Preliminary Acceptance Punchlist

El Paso County – Department of Public Works - Stormwater Section

Project Name:	Monument Academy CDR (road & roundabout)
EDARP Filing Number(s):	CDR201, CON2025 Also Reference: PPR199, CDR191, & MS2110
ESQCP Number:	ESQ1930 (Shared with school construction)
Attendees:	DPW SW: Shannon Mustoe, Joshua Augustenborg, Benjamin Jones DPW Development Services: N/A Developer: Matt Dunston
Date of Walk-through:	09-16-2024
Walk-through Number:	3 rd (First was 07/21/22, second was 01/25/2024)

## SHANNON ROAD PLAN & PROFILE

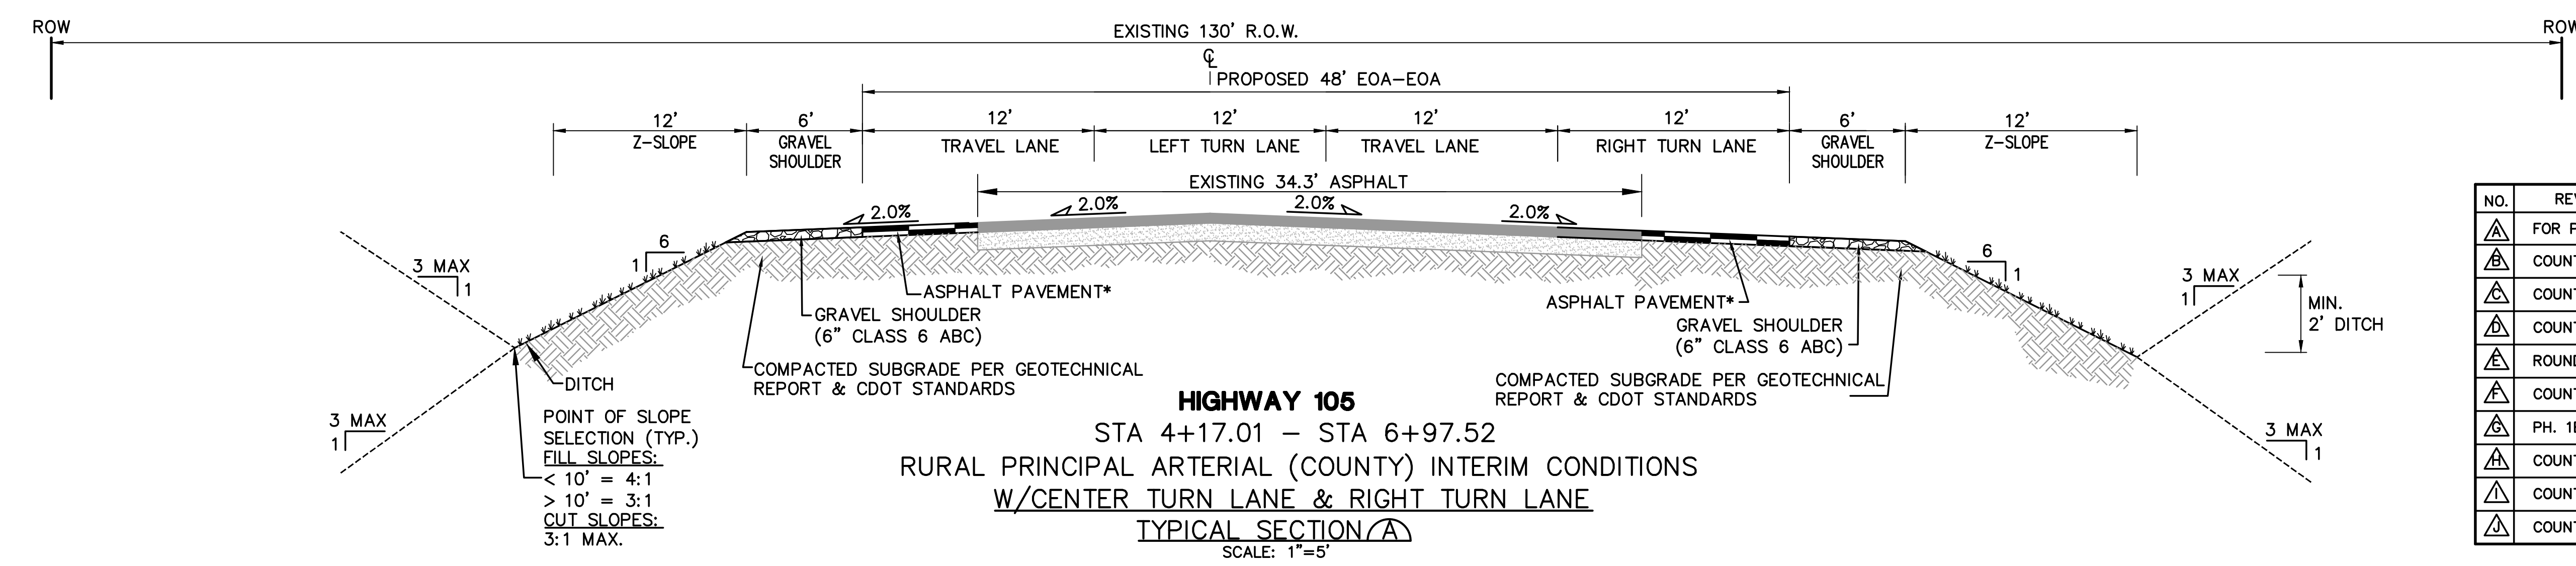
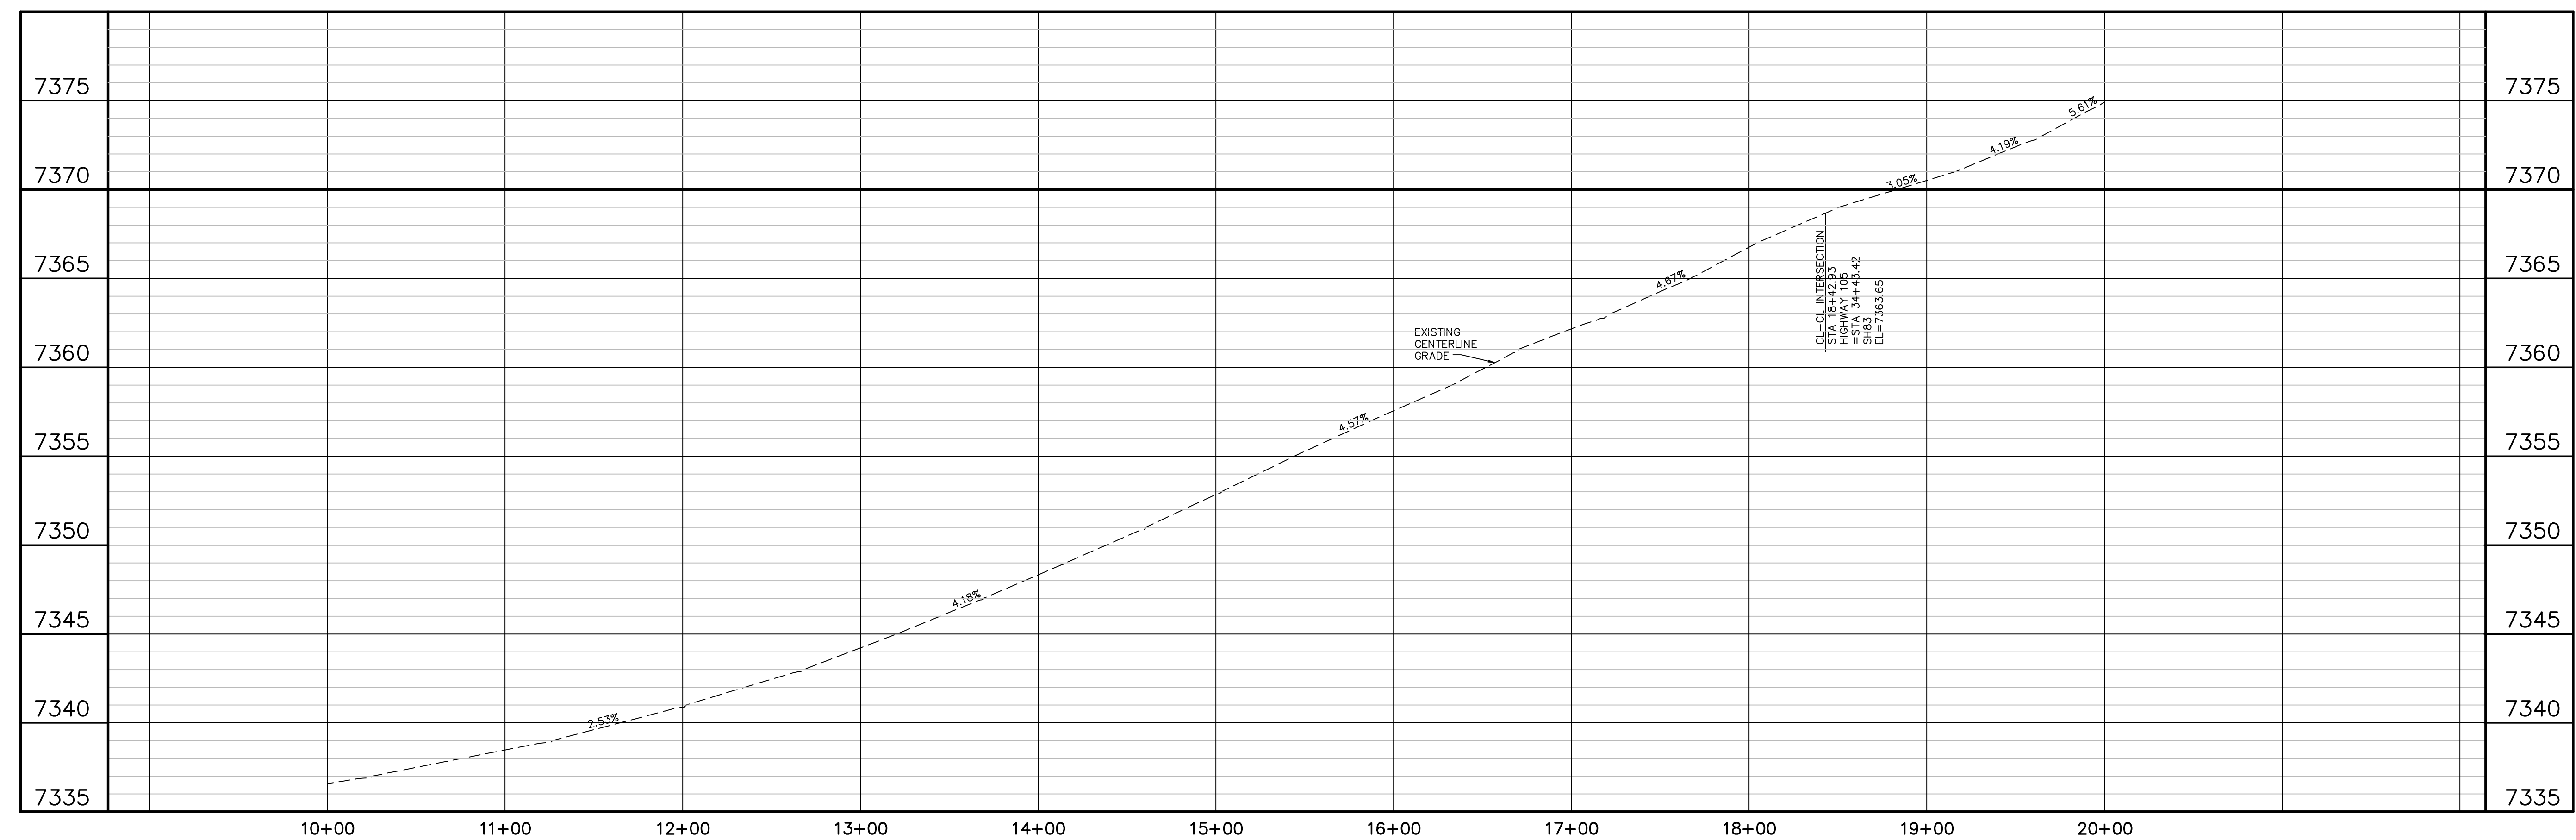
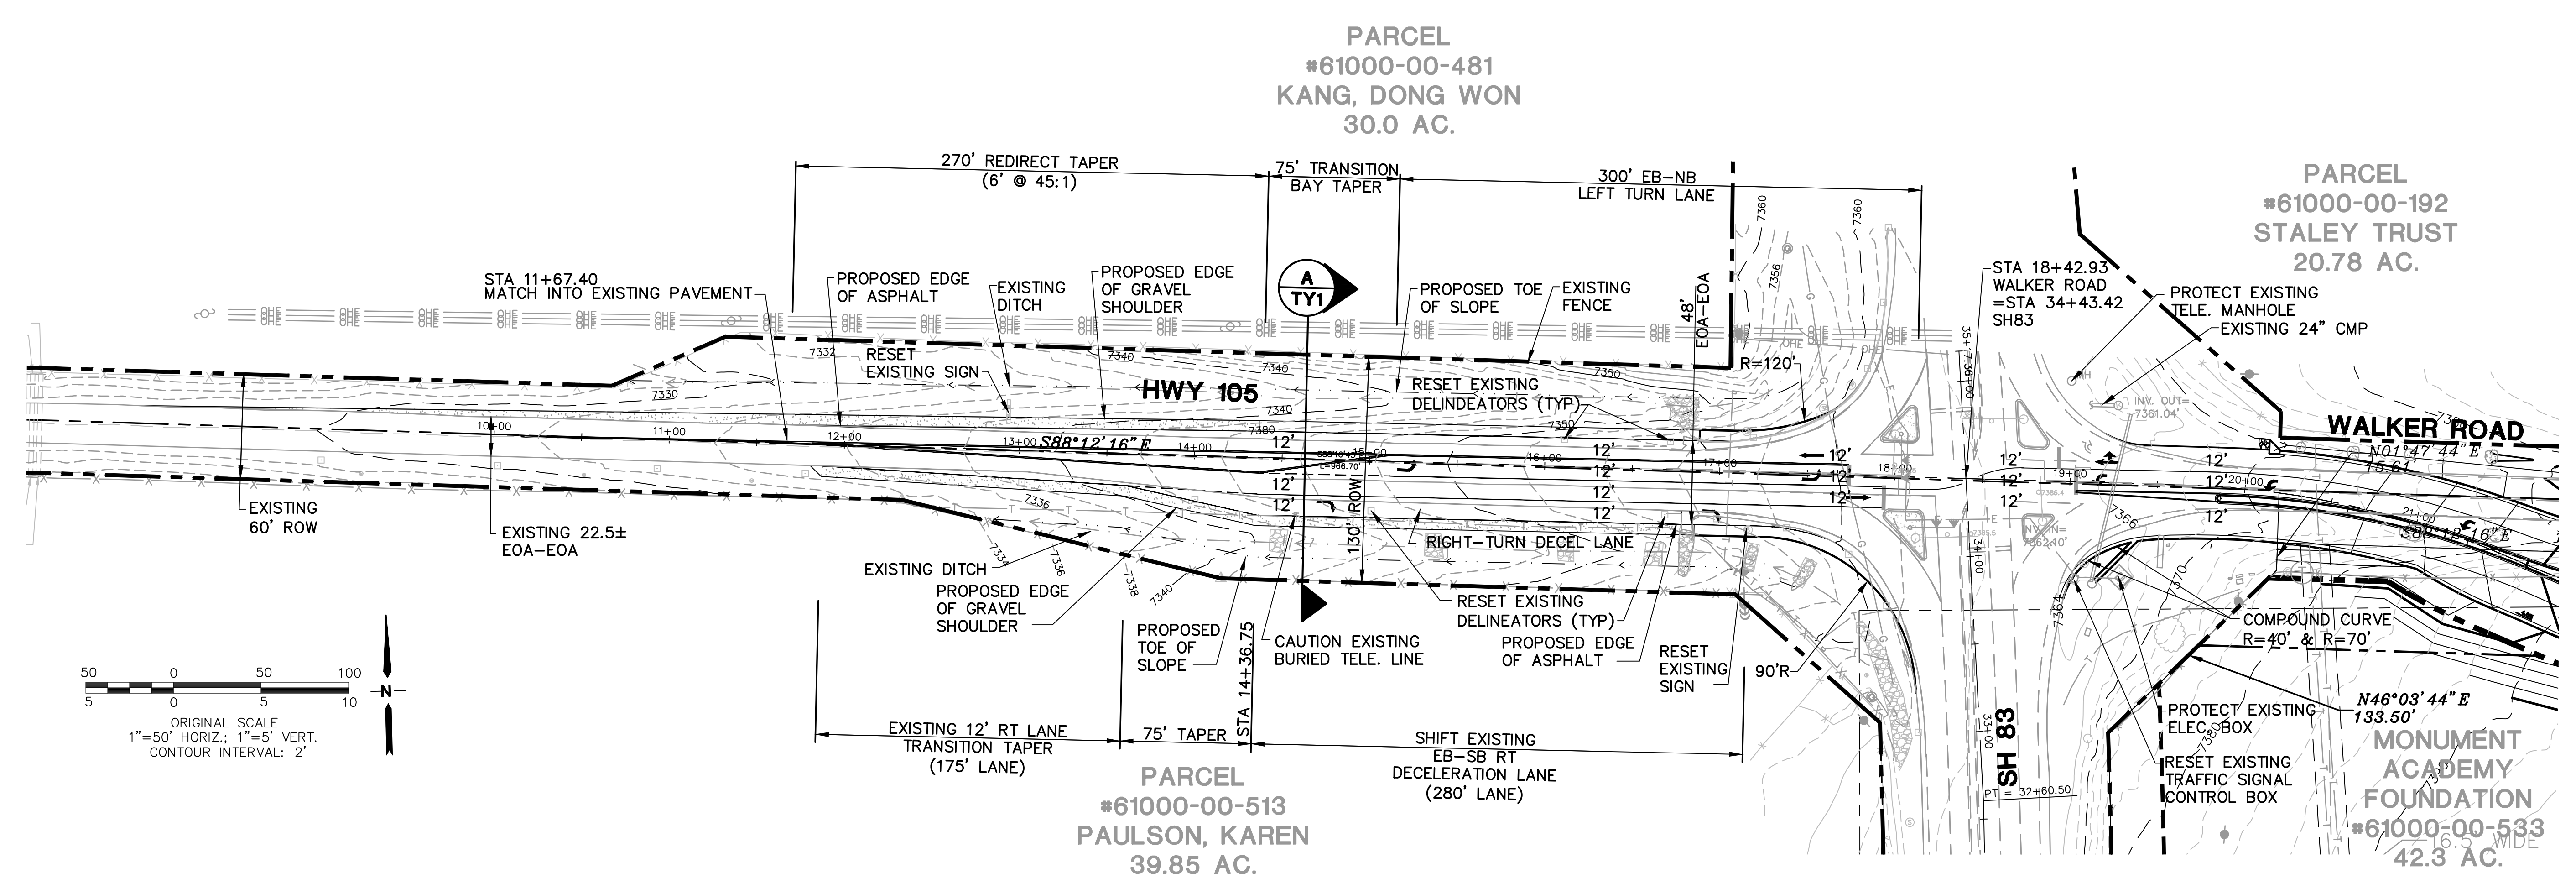
Shannon Road (Sheet PP4)

- Install riprap apron at culvert.

SHEET: **C2.1-HW**

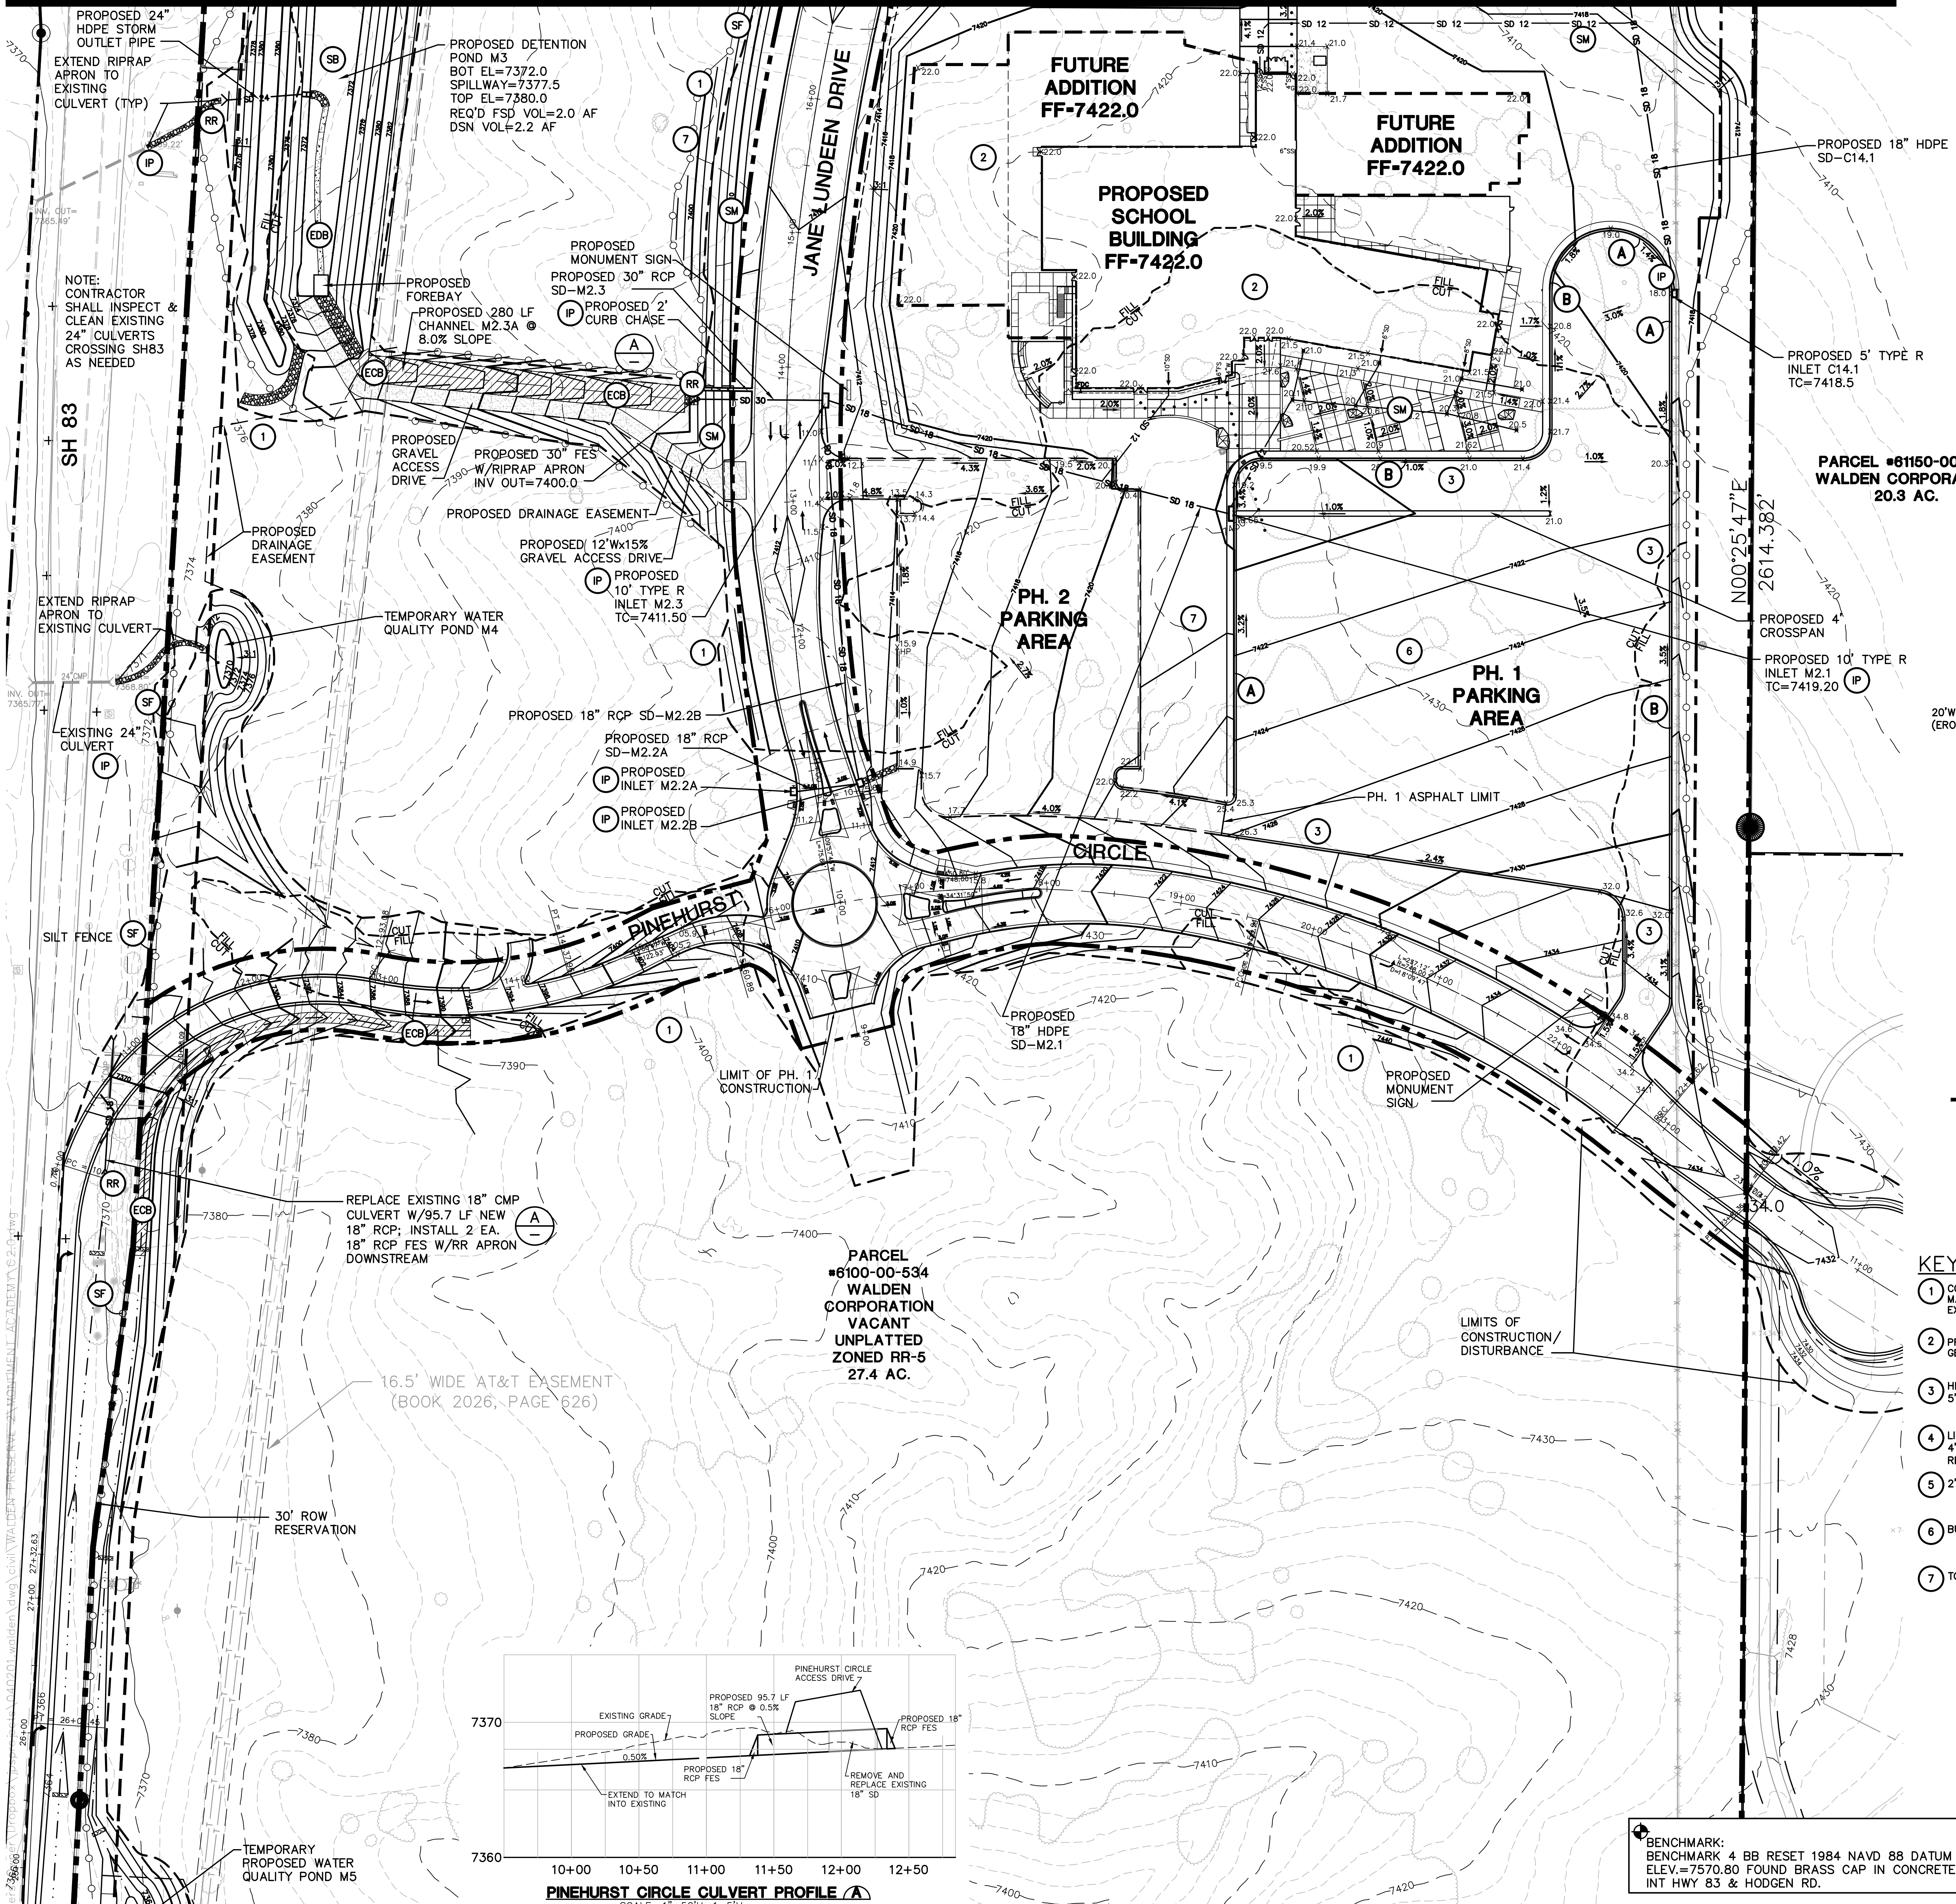
HWY 105 (Sheet C2.1-HW)

- Install riprap check dam on east side per plan.
- Re-install riprap rundown on west side.
- Include installation of FES pipe on east side on as-builts.
